From: Contact Centre (CRM) <contact@ribblevalley.gov.uk>
Sent: 19 November 2024 09:55
To: Planning
Subject: Planning Application Comments - 3/2024/0879 FS-Case-663378019

Planning Application Reference No.: 3/2024/0879

Address of Development: 27-29 Bawdlands
Clitheroe BB7 2LA

Client: Boutique Homes Ltd		
Project: Proposed Alterations 27-29 Bawdlands Clitheroe		
Dwg title: Existing Side Elevation		
Scale @ A3: 1:50	Date: 26.02.24	Drawn by: PD
Drawing no. 1569 - 2 - 05		Rev. -

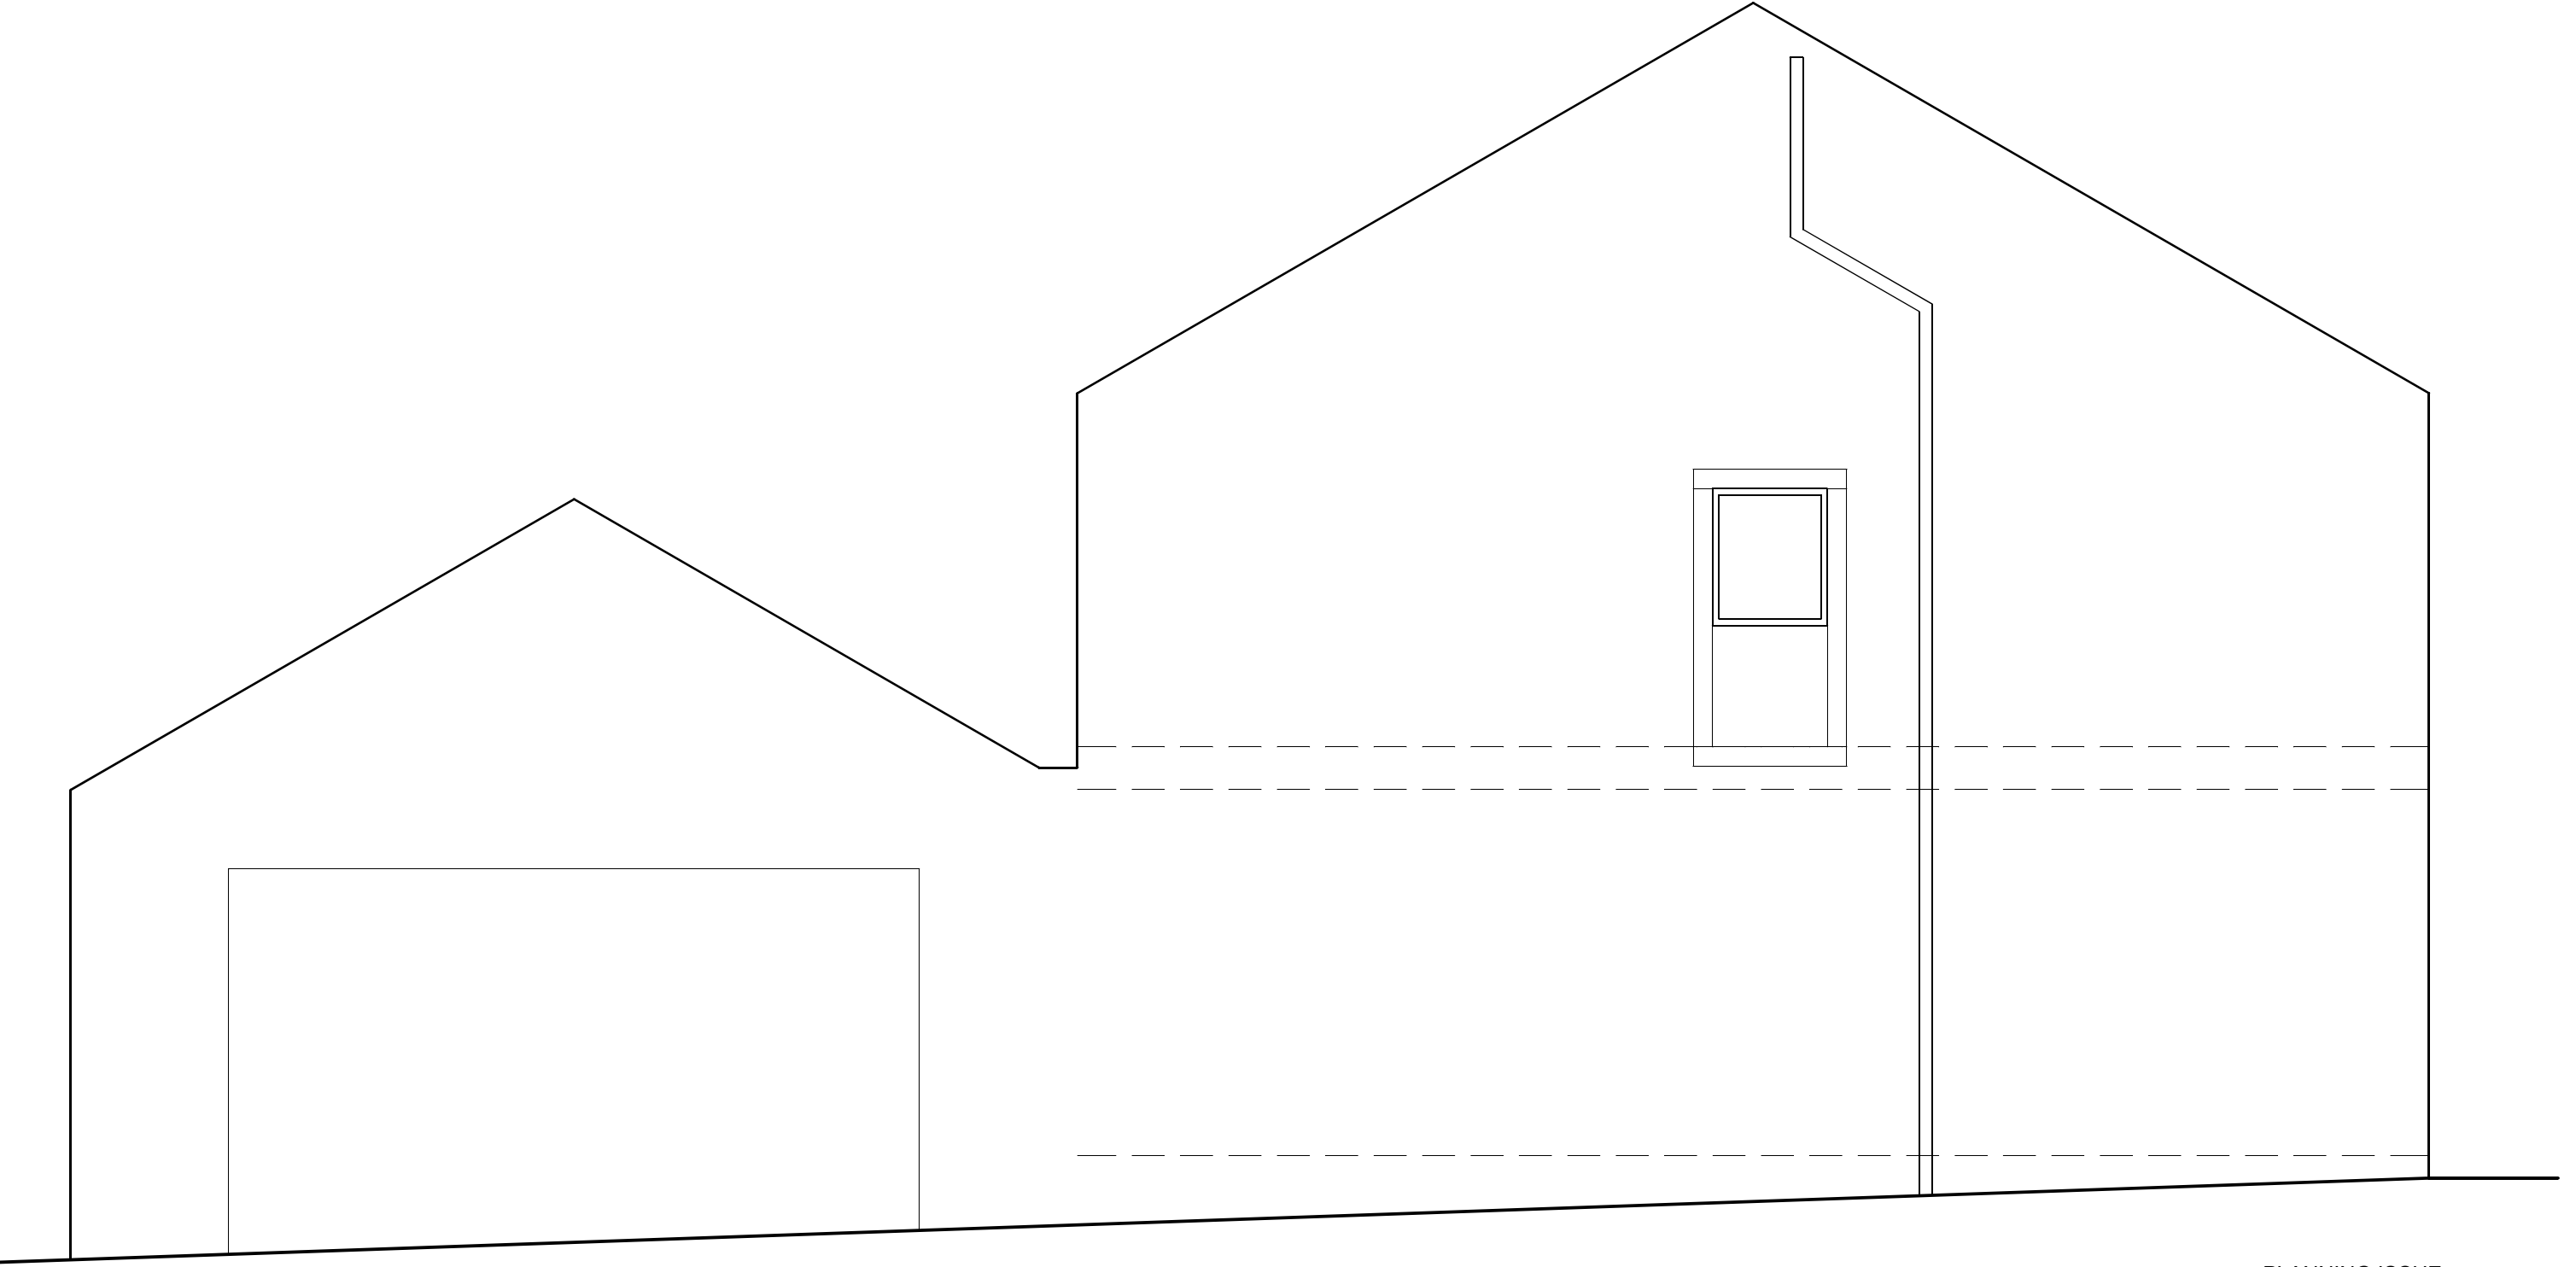
Comments: I note that this application makes no mention of the new door and window openings which have already been constructed on the Corporation Street gable of this property without planning approval. Am I correct in presuming that these openings will be built up again and the wall restored to its former state if this application were to be approved?

Comments: If this application is accepted at face value will the window and door openings already created without planning approval on Corporation Street be reinstated. This will leave the four flats on application 3/2024/0552 presently under appeal on Appeal Reference APP/T2350/W/24/3354200 without bin and cycle store or access.
This application requires further detail .
